Wise Engineering
3915 Old Fairground Rd.
Angier, NC 27501
(919)894-2203

November 24, 2019

Subject: 12 Broadlake Ln., Spring Lake, NC 28390

I have reviewed the home being constructed at the subject address. Specifically, I reviewed the brick lintels to be used to support the brick veneer.

Overhang Detail - Brick

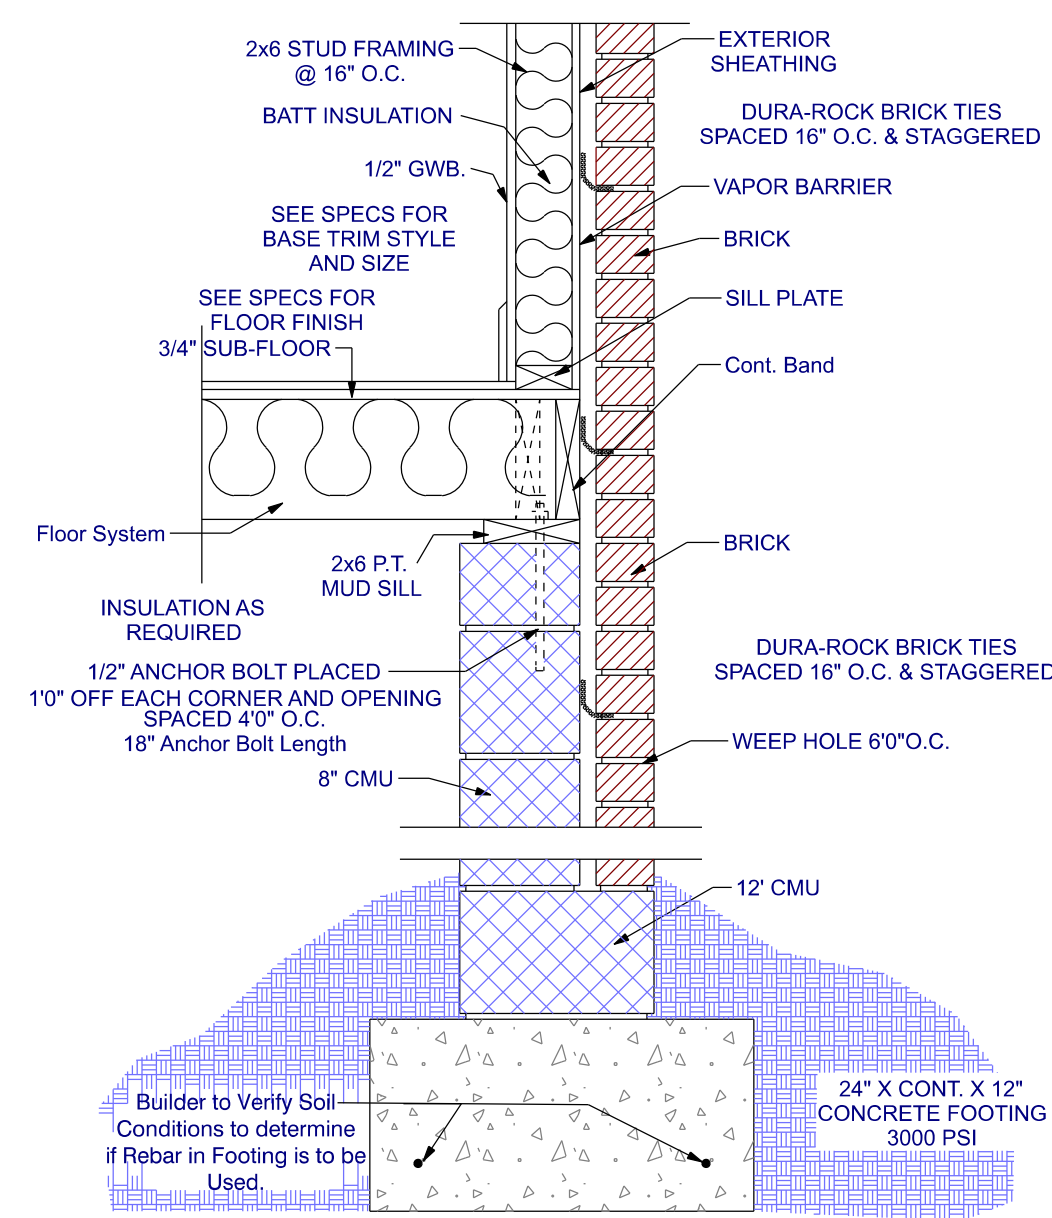
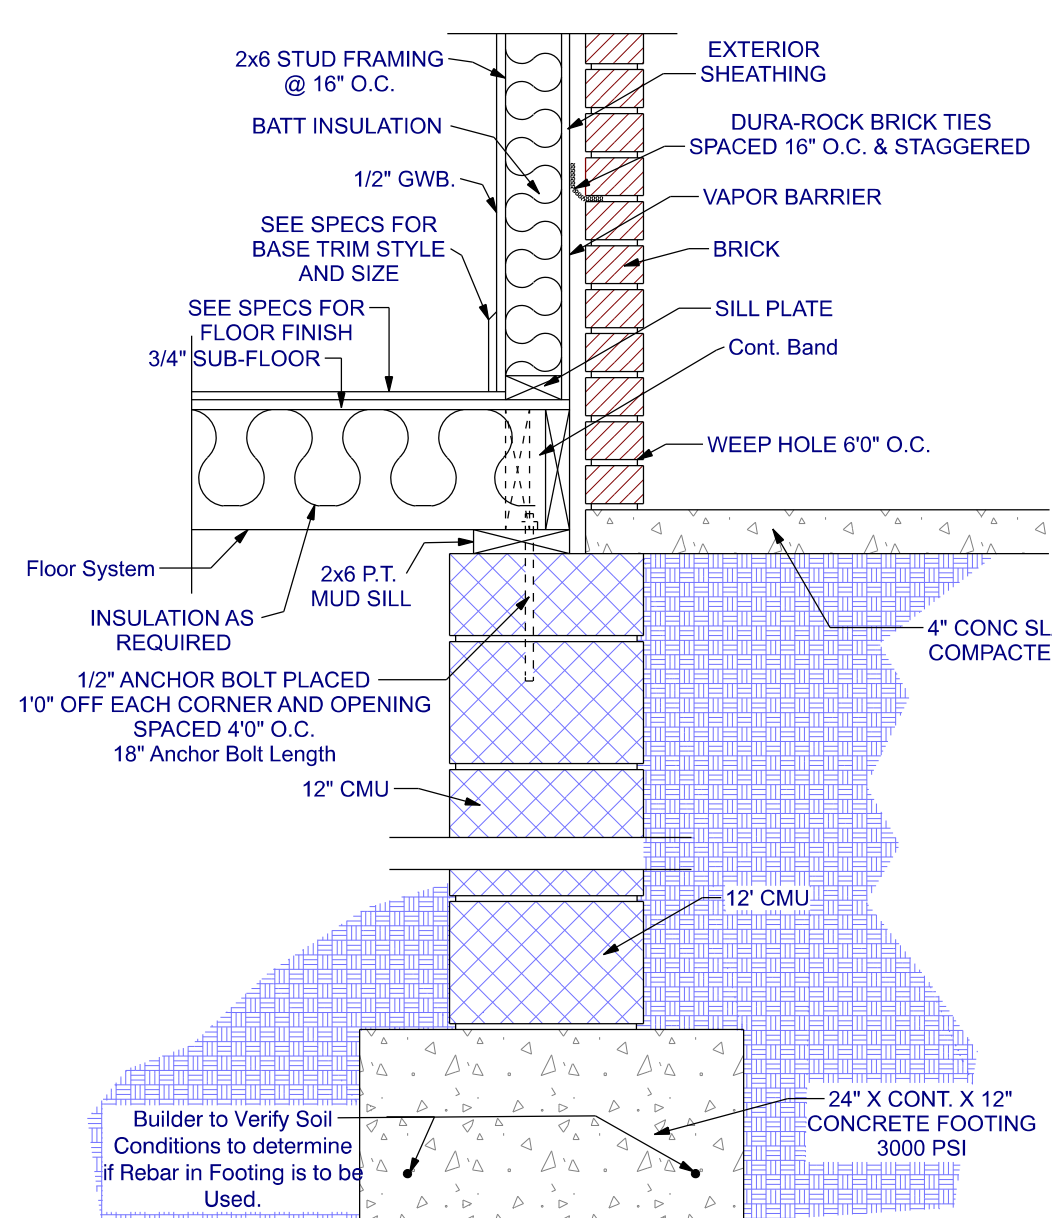
Based on my observations and analysis, the lintels used are adequate to support the brick as installed. The lintels specified for the home are as follows:

1. For spans 4'-0" and less – use L3.5"x3.5"x1/4" (steel angle)
2. For spans 4'-0" to 8'-0" – use L5"x3.5"x5/16" (steel angle)

The above specified steel lintels are adequate to support the brick as constructed without bolting to the headers. If you need additional information or have other questions, please let us know.
